**Our Case Number:** ABP-314597-22

**Re:** BusConnects Galway Cross-City Link Scheme.  
University Road to Dublin Road, Galway City.

**Proposal – Bus Connects Galway Cross-City Link (University Road to Dublin Road), Compulsory Purchase Order No CCL-CPO-001,2022.**

**Landowner – Fairgreen Coach Station Limited.**

Role	Transport Infrastructure
Suitability	Planning
Arup Job No	253352-00
Name	BCG-GA-00-07
Rev	PL01

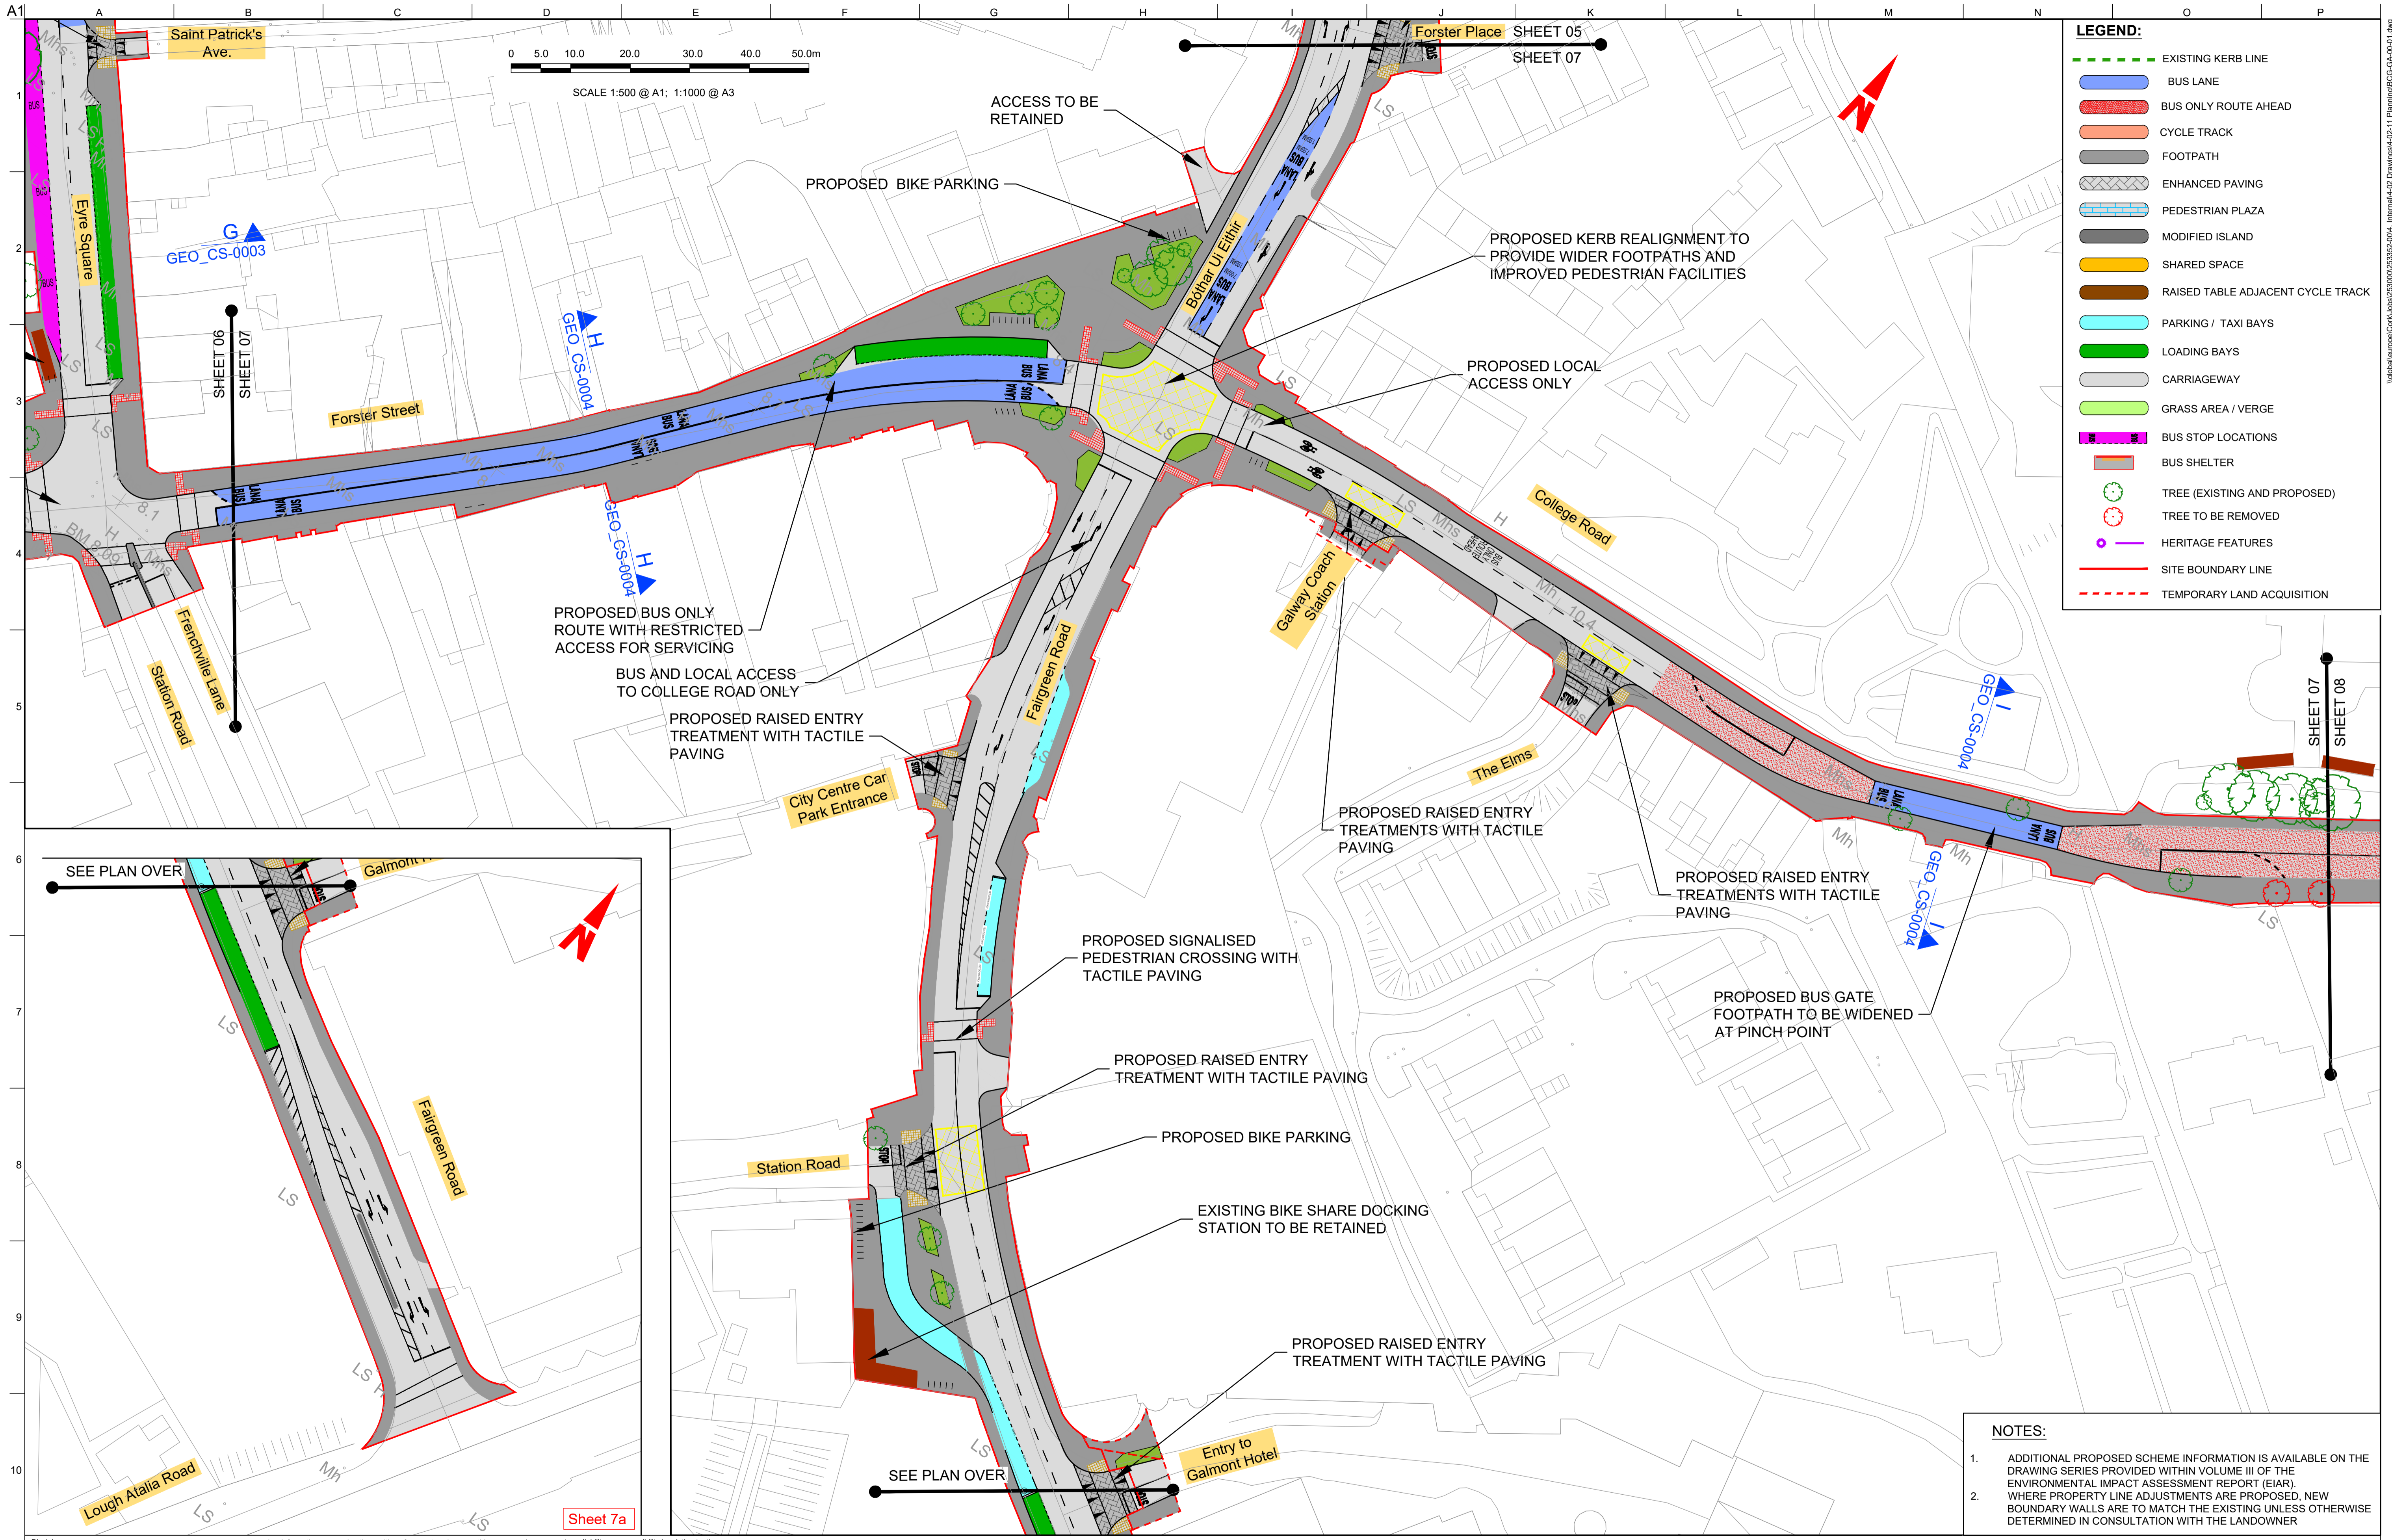
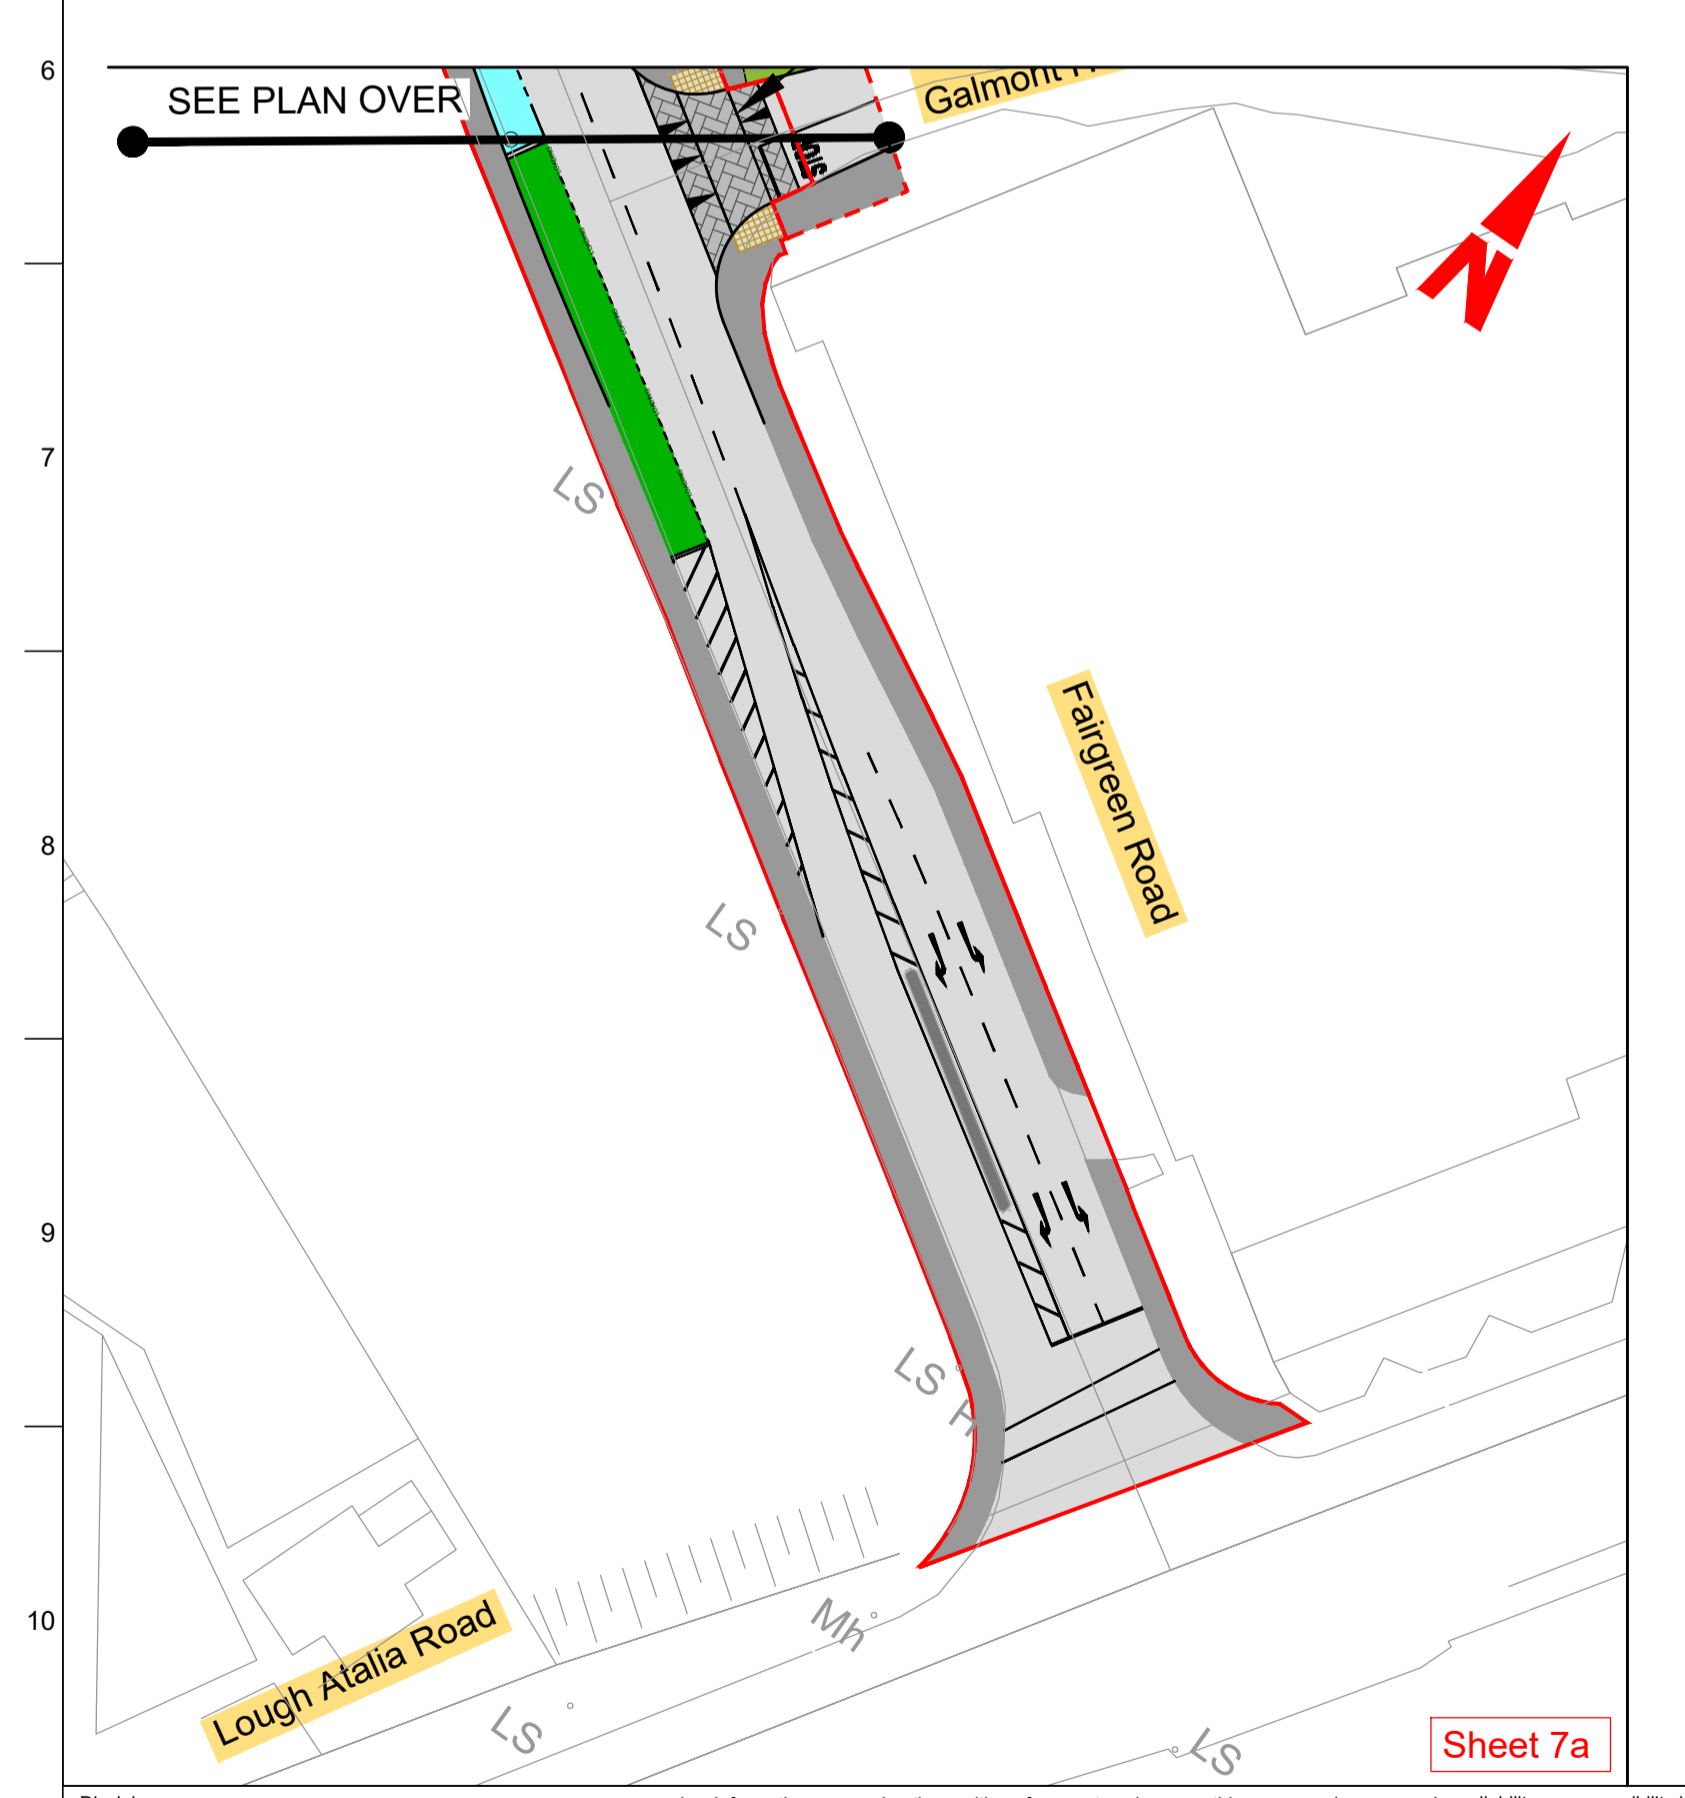
- f) To the positioning of the proposed pedestrian crossing adjacent to the exit route from the Coach Station is considered dangerous (Figure A7: Layout 7 of 13). The restricted space for maneuvering a coach when exiting the station, places pedestrians waiting to cross the road in a dangerous position, whether the coach is exiting either left or right. The damage to the current traffic sign is evidence of the dangers posed to pedestrians using the proposed crossing.

- a) The proposed acquisition will remove the ability of their clients, several private coach operators, and the traveling public to access the Coach Station.
- b) No detail has been supplied as how continuous access to the property will be maintained during construction.
- c) The proposed positioning of the pedestrian crossing abutting the coach exit route from the coach station is dangerous as previously stated. A location closer to the main pedestrian access to the coach station would be more appropriate.
